Australian Government
Department of Defence
Estate and Infrastructure Group

**RE: SSD 7237 REDEVELOPMENT OF ARTHUR PHILIP HIGH SCHOOL AND
PARRAMATTA PUBLIC SCHOOL**

14 June 2016

Shadow Diagrams

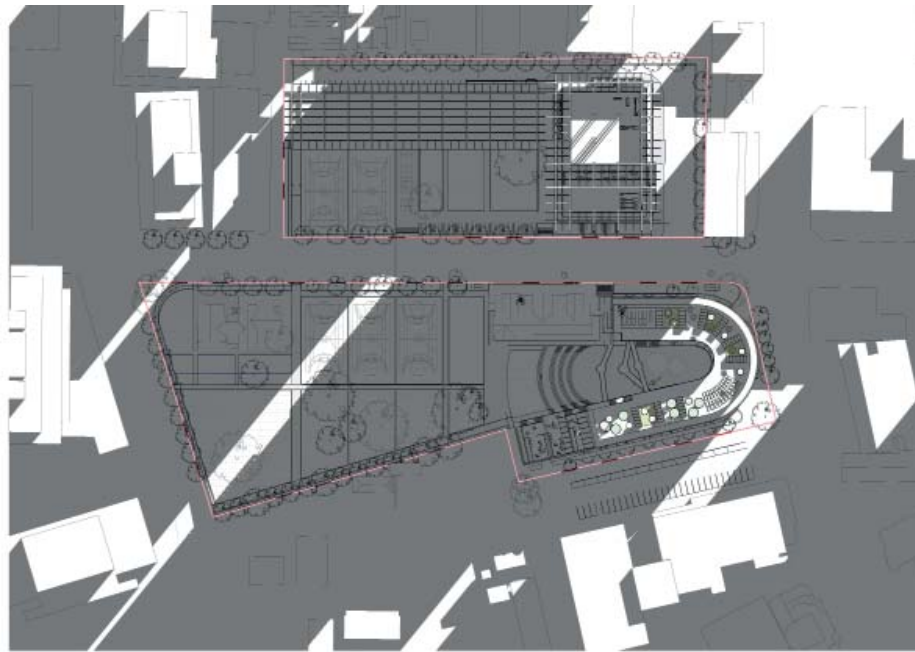
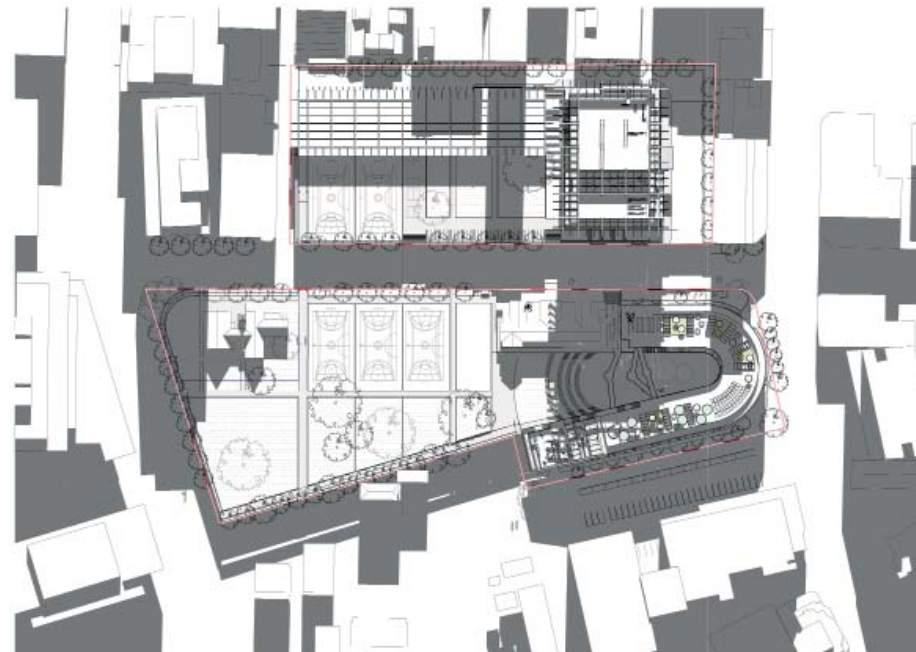
Defence is concerned that the proposed 17 storey building may cause overshadowing of the Lancer Barracks Precinct and requests that an appropriate assessment as to the impact of such overshadowing is appropriately assessed and considered.
